Recommendation Report for Planning Permission for Works or Extension to a Dwelling

REF NO: P/45/20/HH

LOCATION: 9 Manor Park
Pagham
PO21 3JS

PROPOSAL: Replacement of outbuilding.

MAY 2020 (A4) DEG 2A

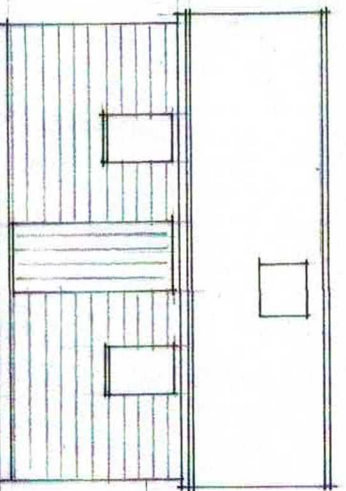
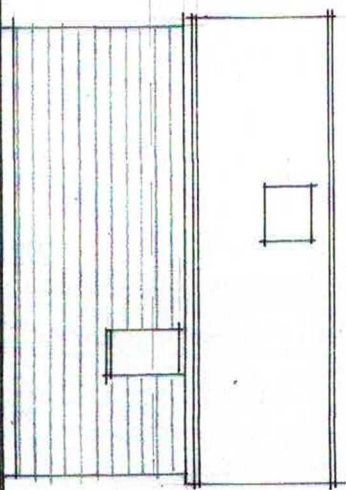
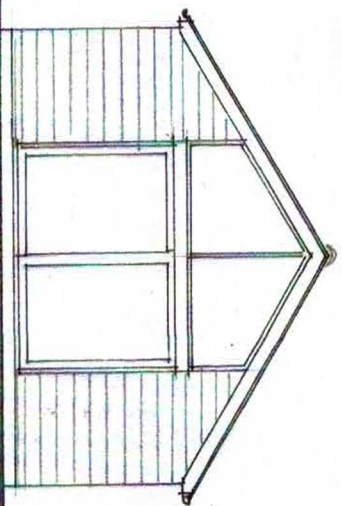
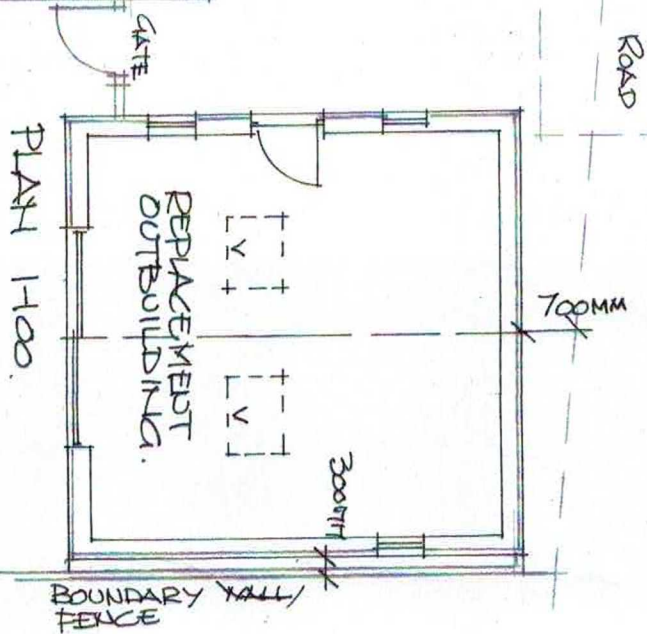
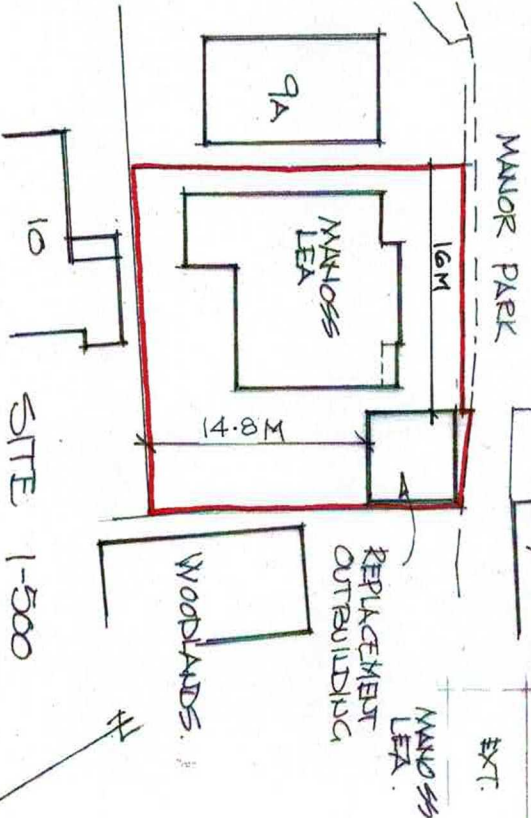
The development is not considered to have any significant overshadowing or overbearing impact as a result of both the aspect of the development site, and the boundary treatment present at the site. The development features windows on its South, Eastern and Western elevations that face into the site, however, as the proposal is single storey, the available views would be no different from those that are currently available from the front garden.

Whilst there will be an increase in the height of the outbuilding the change is not considered to have a demonstrable impact on the neighbouring dwellings. The property to the North will have more views available of the outbuilding but these are not considered to be to a harmful extent such that would lead to the refusal of the application.

The development is not considered to give rise to any significant change in loss of light to neighbouring dwellings. There is the potential for the outbuildings use to be changed and it is noted that this is the concern on the Parish Council, as such there is a condition placed onto the application in order to ensure the use does not change.

- 3 The outbuilding hereby permitted shall be occupied solely for purposes ancillary to the occupation and enjoyment of 9 Manor Park, Pagham and shall not be used as a separate unit of accommodation or as a commercial unit.
